STATE OF WASHINGTON  
DEPARTMENT OF ECOLOGY

Re: SE-19-00007

Thank you for the opportunity to comment on the mitigated determination of nonsignificance for the Wiehl Road Improvement project, proposed by Kittitas County Public Works. We have reviewed the documents and have the following comments.

Exhibit 1: Wiehl Road Improvements Nearby Waterways

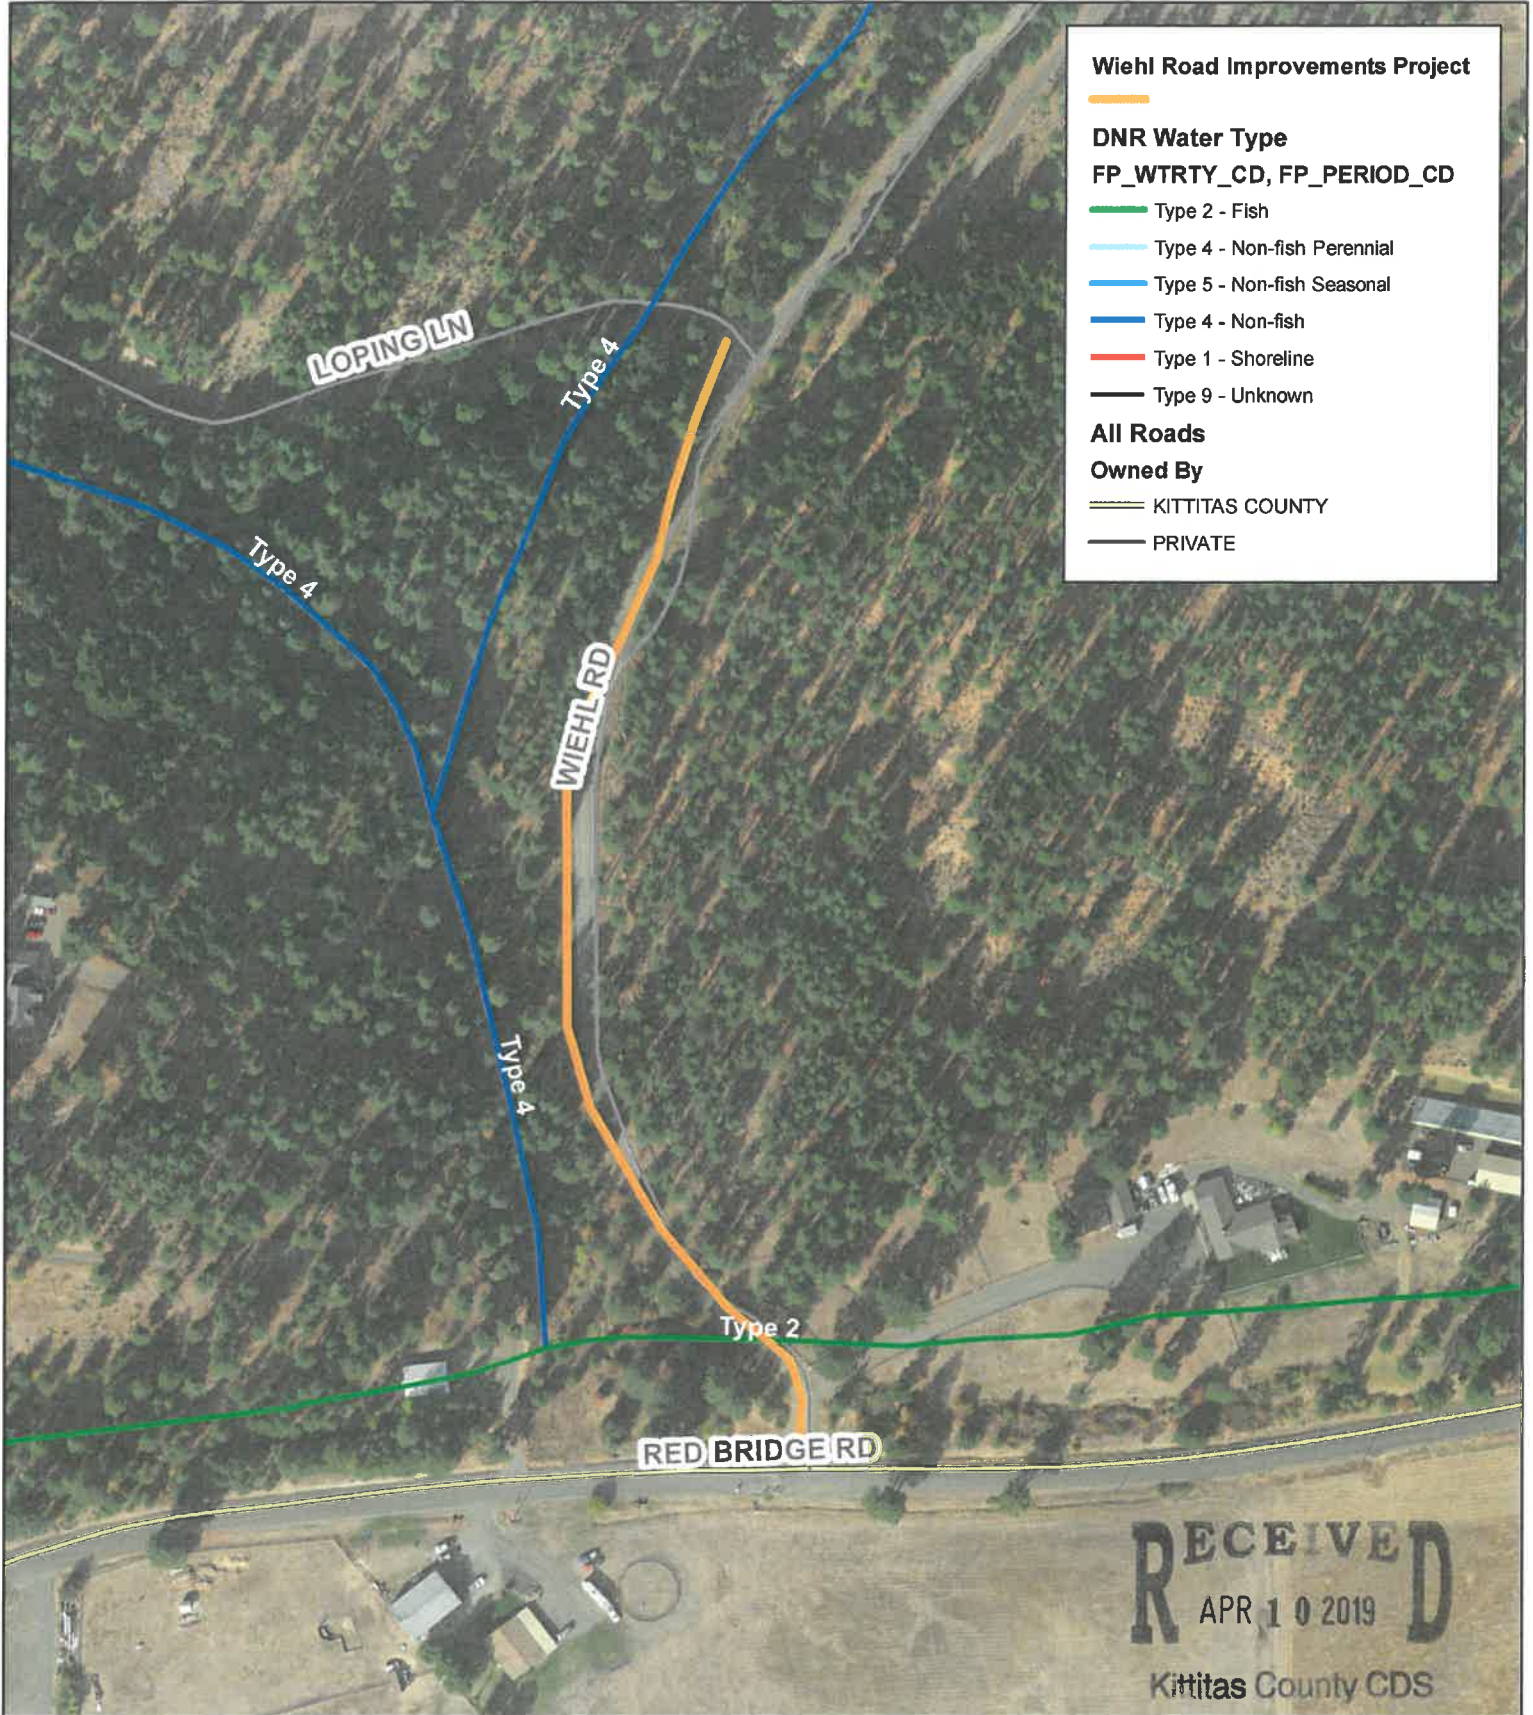
The proposed project is included in the program area of the Teanaway Temperature Total Maximum Daily Load (TMDL) water quality improvement program, which addresses water temperature impairments. The proposed project is also included in a separate sediment-reduction TMDL that covers the entire upper Yakima River watershed. Required best management practices for both TMDL programs include prevention of sediment input into the Teanaway River and all its tributaries. At high flows, it appears that the unnamed creek adjacent to Wiehl Road now crosses under Red Bridge Road and enters a roadside ditch. According to the SEPA application, water in roadside ditches in this area is ultimately conveyed to the Teanaway River.

Therefore, it will be important to prevent sediment from entering the unnamed creek during all phases of project work. Sudden intense summer rain storms can occur in the Teanaway valley, and project engineers should be prepared to prevent sediment delivery to the unnamed creek during such an event. In general, all project planning, development, and future use of the site needs to include water quality protection.
